4.13 STYGOFAUNA

4.13.1 Sampling Program

Figure 4: Stygofauna Monitoring Bore Locations

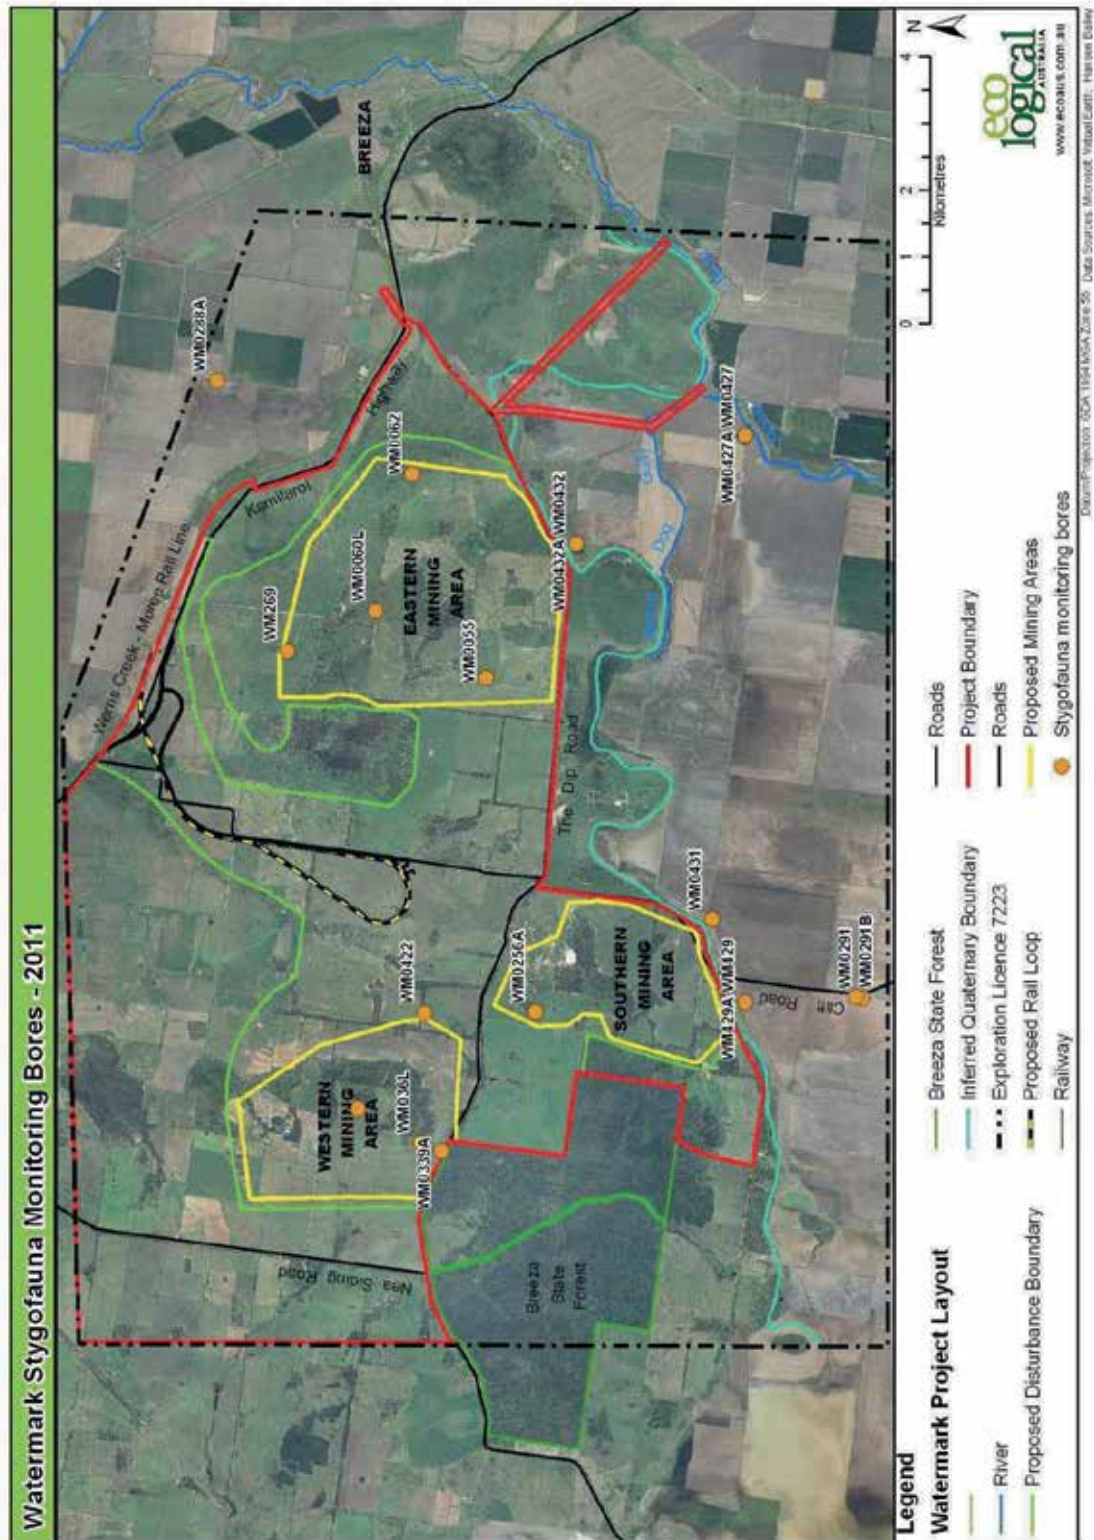
This section responds to the submissions from stakeholders regarding the adequacy of the sampling program, in particular why the survey was limited to a single bore survey and included only very few bores in alluvial and colluvial geological units and none in Tertiary volcanics or within the Breeza State Forest.

Submission reference: RA13 and SIG10

Summary response: The Stygofauna Impact Assessment for the Project included sampling from 20 bores within the alluvium and colluvium (six bores), interburden (five bores), weathered Permian (five bores) and target coal seams (four bores). Sampling within the Tertiary volcanics was carried out and found no Stygofauna present. Water quality analysis in the bores in the Breeza State Forest identified conditions unfavourable for hosting stygofauna.

Following the desktop study, samples were collected from 20 bores (not one bore as suggested in a submission), screened within a range of strata present within the Project Boundary and the immediate vicinity, focusing on aquifers in the Narrabri and Gunnedah Formations and the weathered part of the Permian aquifers, as these were identified as the aquifers most suitable for stygofauna. EC was also considered during bore selection, with preference given to bores with favourable EC values for stygofauna occupation (i.e. EC <5,000 $\mu\text{S}/\text{cm}$).

The bores sampled targeted the geological strata to be impacted by the Project and those identified as potential stygofauna habitat within the alluvium and colluvium (six bores), interburden (five bores), weathered Permian (five bores) and target coal seams (four bores).

No stygofauna were identified within the Project Boundary and its surrounds during the sampling program.
